**From:** Abiel X. Carrillo  
**To:** ["Vinny Perea"](#)  
**Cc:** ["Ron Bohannon"](#); [Cherne, Curtis](#)  
**Subject:** Holly Shopping Center - C18D042D - Stamp Date 2-17-2016  
**Date:** Wednesday, March 09, 2016 4:33:00 PM

Based upon the information provided in your submittal received 2-17-2016, the above referenced Grading and Drainage Plan/Report is approved for Site Plan for Building Permit action by the DRB.

# **DRAINAGE REPORT**

## **Lot 2-A and 3-A Del Norte Plaza**

DETAIL A - HC RAMP
NTS

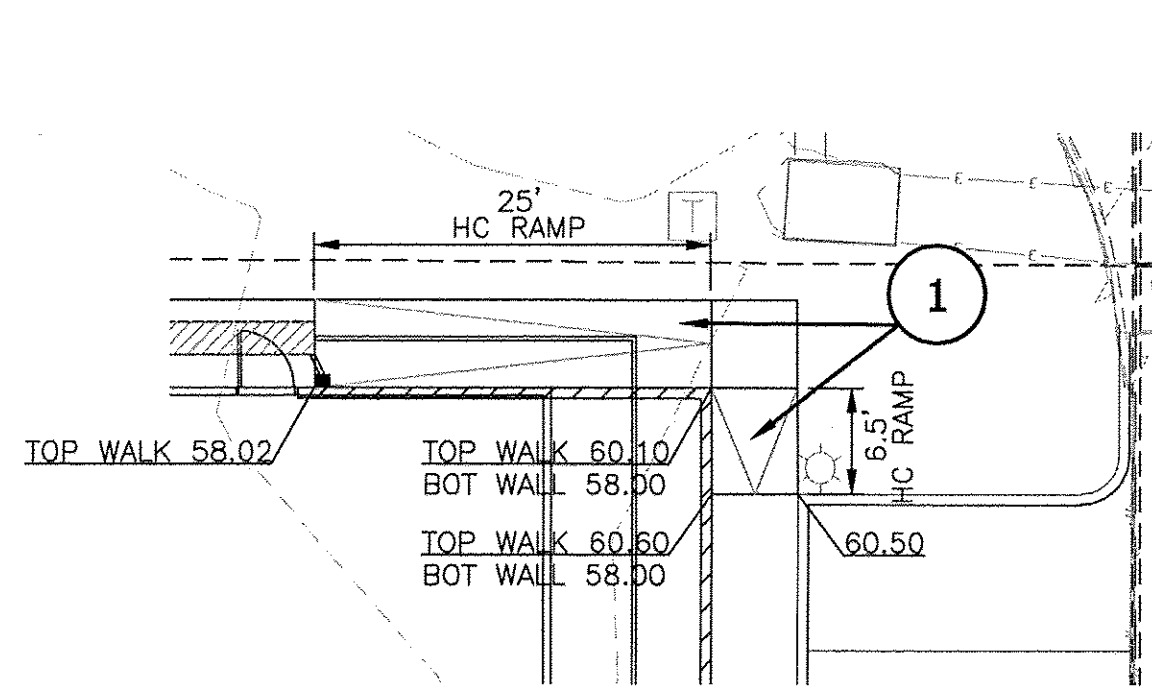
6. Label the intended cross slope of the sidewalk on Section A-A.
7. We recommend shifting the 12:1 wheelchair ramp that is in front of the easternmost retail space of the larger building slightly to the west so that the top of the ramp lines up with the parking curb; this would remove a potential tripping hazard and provide a better turning space for wheelchairs at the top of the ramp.

DETAIL B - TRENCH DRAIN DETAIL
NTS

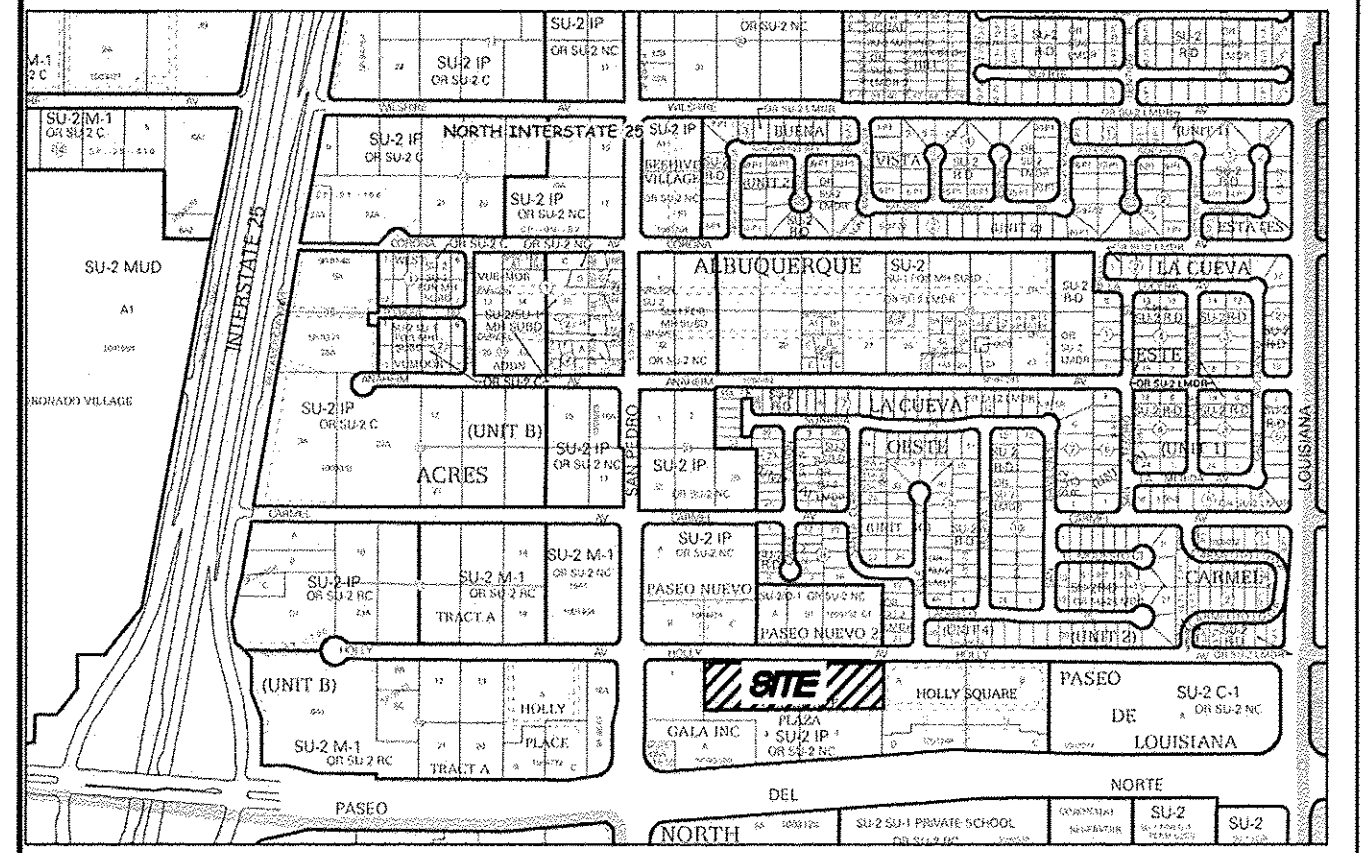
4. Provide benchmark information, unless it is called out on a different sheet of the construction set.
5. Detail B describes the use of a trench drain to provide an outfall for the roof drains of the larger building. A type of grate should be called out that complies with ADA standards and is "heel safe", since it is proposed along the center of the sidewalk. If the sidewalk is intended to drain to the west (without needing to enter the trench drain) we recommend calling out a solid metal top.

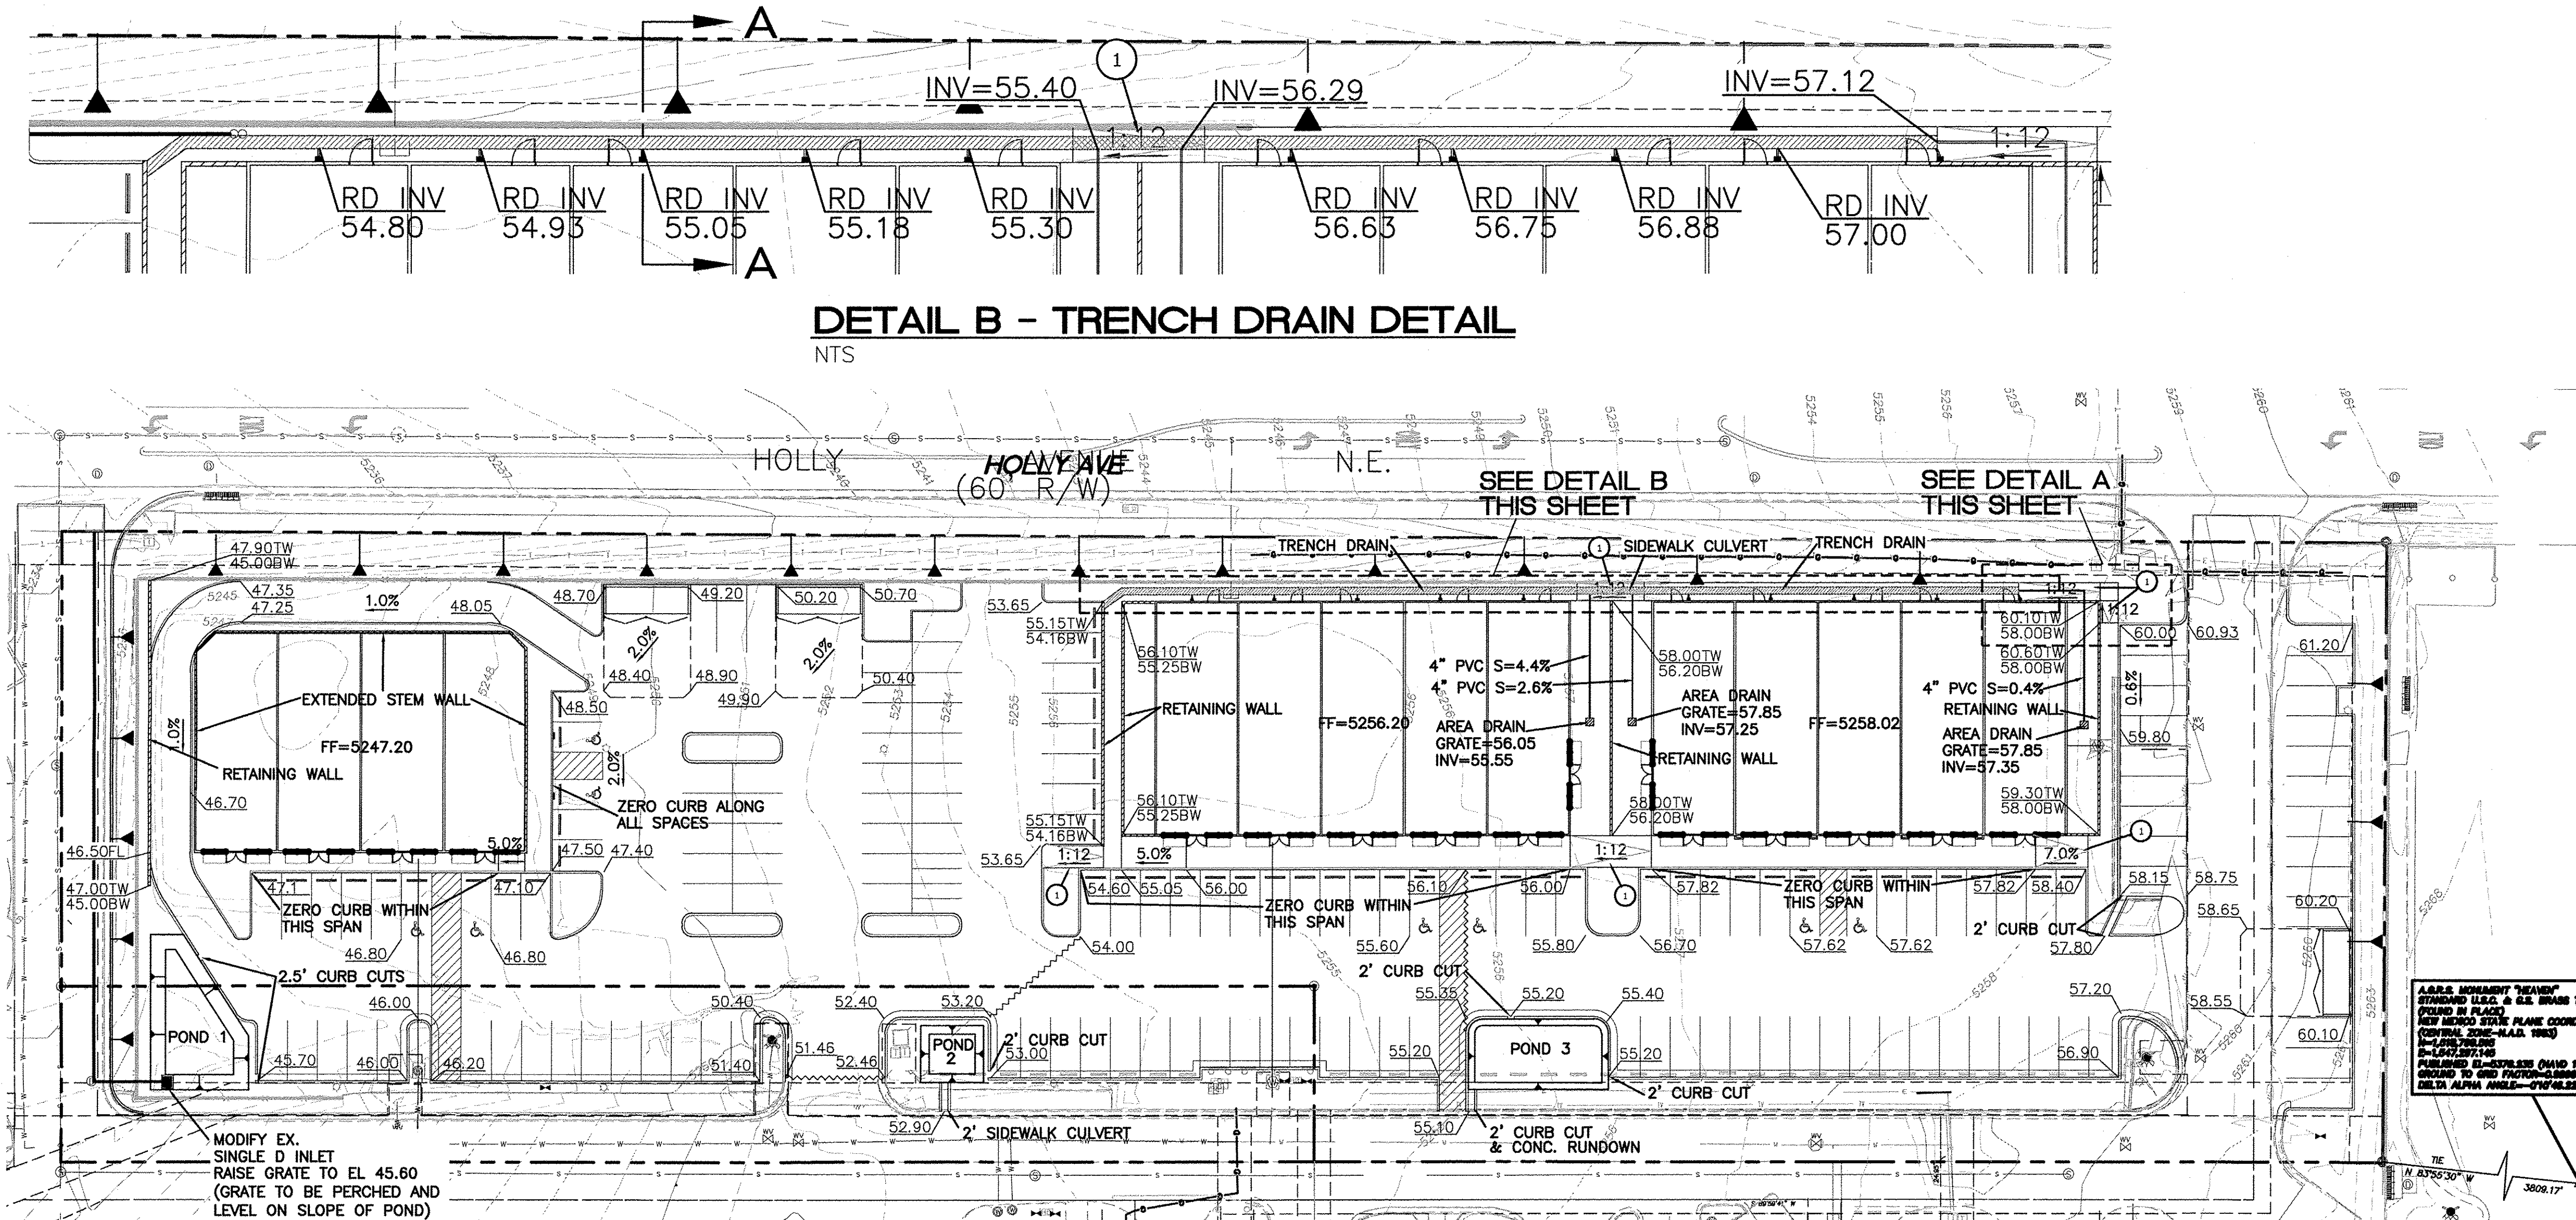
3. The existing inlet in the proposed "Pond 1" is called to be modified. Clarify what the modification involves.
  - a. The grate is shown on the slope of the pond; it is assumed that the box will be perched to ensure that the inlet elevation is level and set at EL 45.60 as called out.
